April 25, 2022

Dear Miss Welch
RE: Cutts planning application M/20/22/HH

We remain concerned about the Cutts' proposed plans for rebuilding their bungalow as a full two-storey house, given their lengthy response dated 14 April, and the following document addresses their points in turn. In particular, we are concerned by the conclusion from Mr Cutts that he believes his proposal can be undertaken as a permitted development and that consequently he doesn't need anyone's permission to go ahead.

client	project	drawing	date	drawn	drawing no	revision
Jane Cutts	Extension at: 48 Lane End Road Middleton-On-Sea, PO22 6LT	Proposed elevations	Oct 21	pd	0358 / 102	D
			scale 1:100 @ A3	CAD file name:

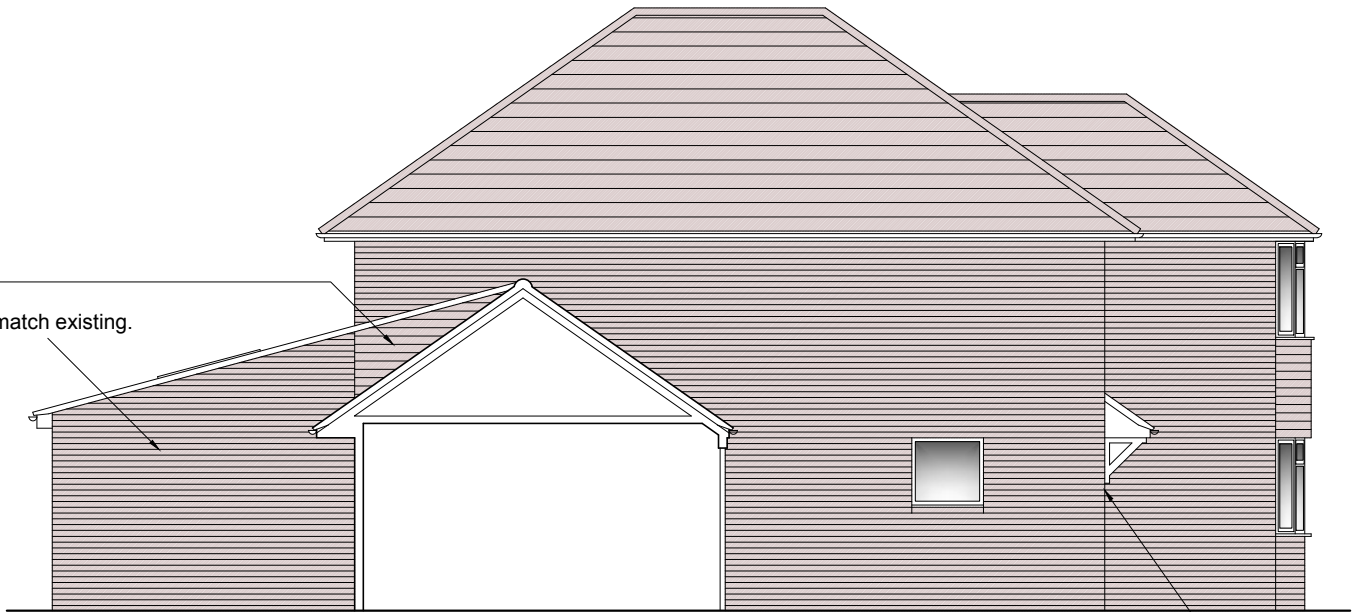
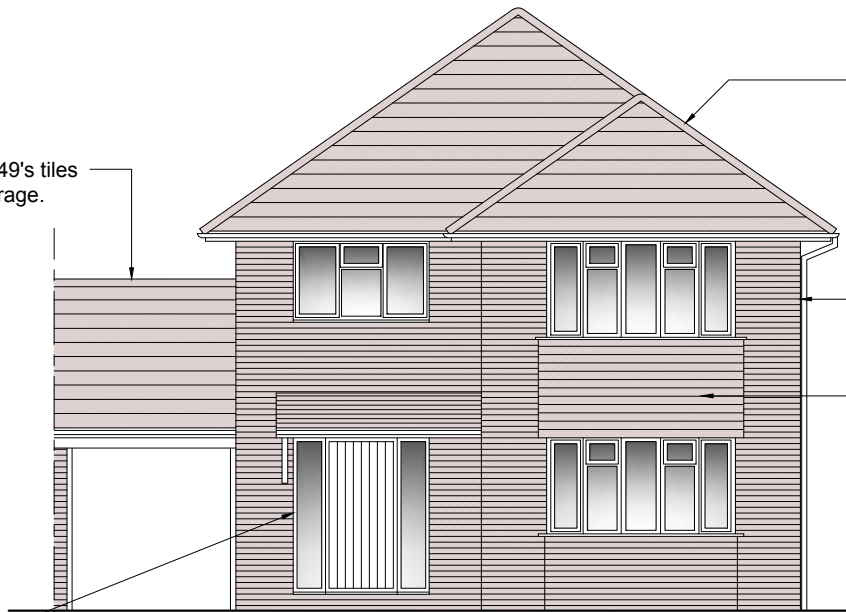
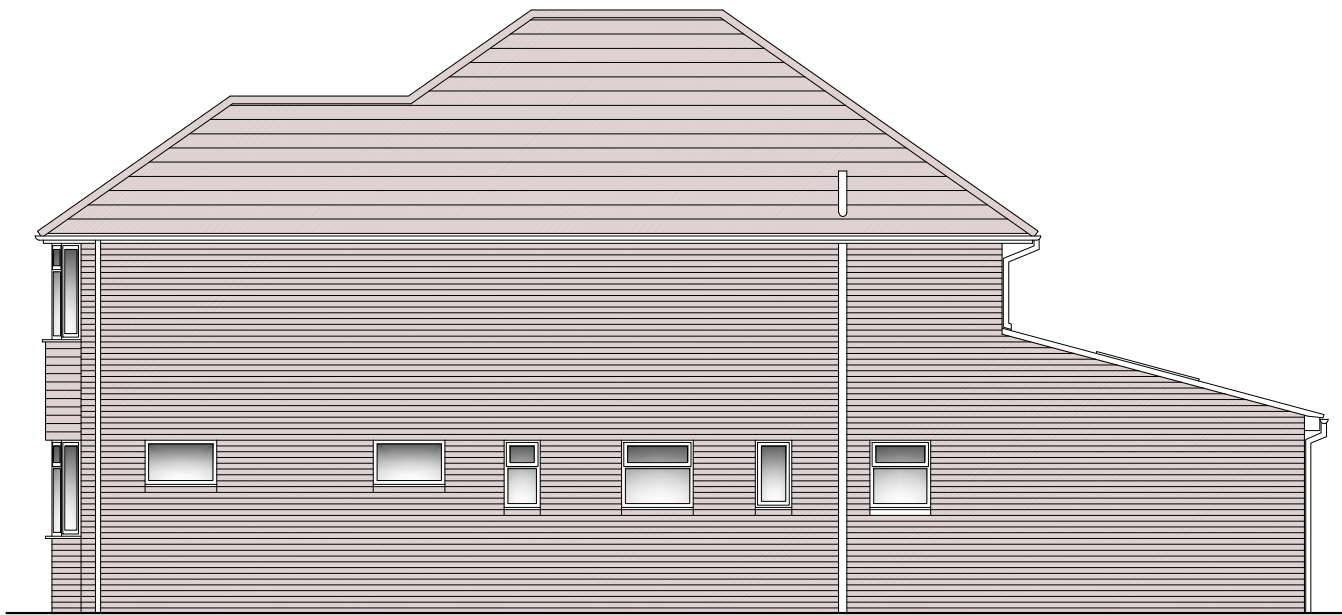
Although the second storey extension will retain the footprint of the original house, as it is not pitched it will tower over their adjoining neighbour at number 50 and will restrict light to both 50 and ourselves at 52, particularly in the winter.
